PLANNING CONSULTATION RESPONSE

From: Transportation Manager

Planning Application Ref. No: 21/00041/APP

Proposed conversion of part ground floor to 2no flats at The Old Coach House Hotel 28 High Street Buckie Moray for Mr Shabaz Mahmood

content
Proposed Elevations

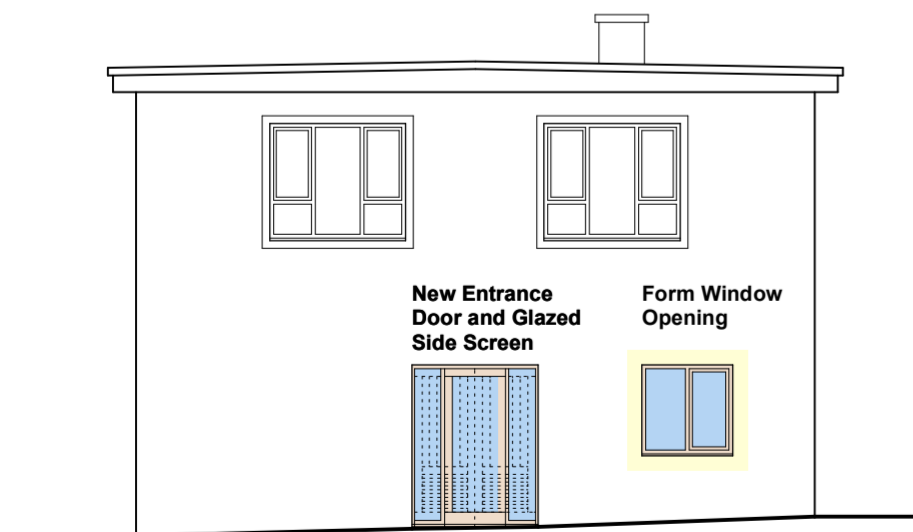
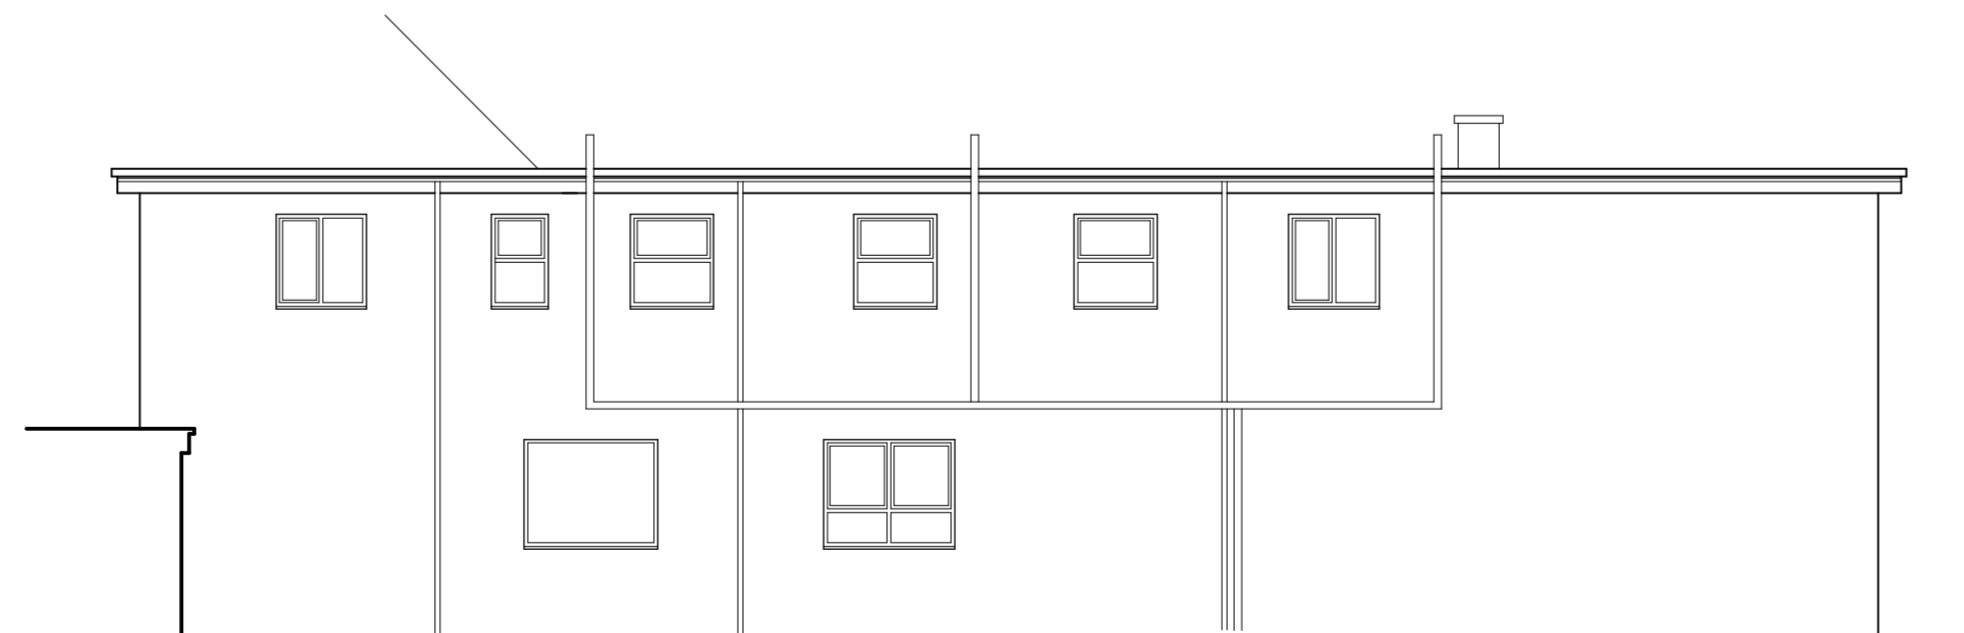
This proposal is for a change of use of a section on an existing hotel, currently used as a bar area to 2no three bed flats and includes alterations to the existing frontage onto the A942 High Street with the formation of a new entrance (and the replacement of an existing door with a window). It is considered that the resulting reduction in parking demand associated with the former bar area would offset on a like for like basis the associated parking requirement for the proposed flats. The site is also located in close proximity to the town centre, with public car parking available nearby. The following conditions would apply:

1. The opening path of the front entrance door onto the A942 High Street shall be fully contained within the site and not encroach onto/over the public footway. Any alterations to the threshold levels must be fully accommodated within the building itself. No alterations to the level of the public footway would be permitted at this location.
